From: paul.marshall@hertfordshire.gov.uk
To: [Planning](#)
Subject: Planning application 6/2019/0434/FULL - 101 Brookmans Avenue
Date: 02 April 2019 12:38:01

District ref: 6/2019/0434/FULL

101 Brookmans Avenue

Erection of 5 x detached family sized dwellings with associated landscaping and off-street parking following demolition of existing buildings

Drawing Title  
 PROPOSED SITE PLAN

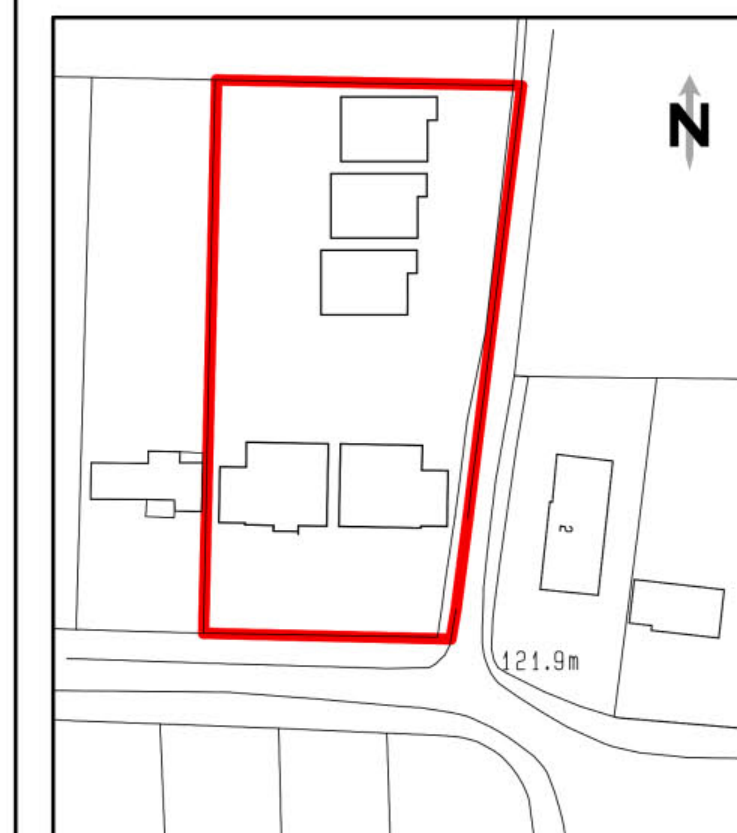
Con1) Concurrent with the use of the accesses on Golf Club Road, visibility splays of 2.4m x 43m shall be provided and permanently maintained in each direction within which there shall be no obstruction to visibility between 600mm and 2m above the carriageway level. Reason: To ensure construction of a satisfactory development and in the interests of highway safety in accordance with Policy 5 of Hertfordshire's Local Transport Plan (adopted 2018). Con2) Prior to the first occupation of the development hereby permitted the vehicular access shall be provided and thereafter retained at the position shown on the approved plan drawing number 485018-4 in accordance with the highway specification. Arrangement shall be made for surface water drainage to be intercepted and disposed of separately so that it does not discharge from or onto the highway carriageway. Reason: To ensure satisfactory access into the site and avoid carriage of extraneous material or surface water from or onto the highway in accordance with Policy 5 of Hertfordshire's Local Transport Plan (adopted 2018). Con3) Prior to the first occupation of the development hereby permitted vehicular and pedestrian access to and egress from the adjoining highway shall be limited to the accesses shown on drawing number 485018-4 only. Any other access or egress shall be permanently closed, and the highway verge shall be reinstated in accordance with a detailed scheme to be agreed with the Local Planning Authority, concurrently with the bringing into use of the new access. Reason: To ensure construction

I have included a condition that visibility splays of 2.4m x 43m should be provided to provide adequate visibility between the accesses for both vehicles and pedestrians using Golf Club Road. This will require the removal of some of the existing vegetation. The two proposed crossovers will need to be built in accordance with the Highway Authority's specification. The proposals include 3 parking spaces per dwelling indicated on Drwg 485018-4 is 4.8 x 2.4 wide with the required 6m clearance which is the recommended dimensions in Manual for Streets 8.3.58 and 8.3.51. Brookmans Avenue is a private road subject to traffic calming therefore, the proposed crossover is not subject to the Highway Authority specification.
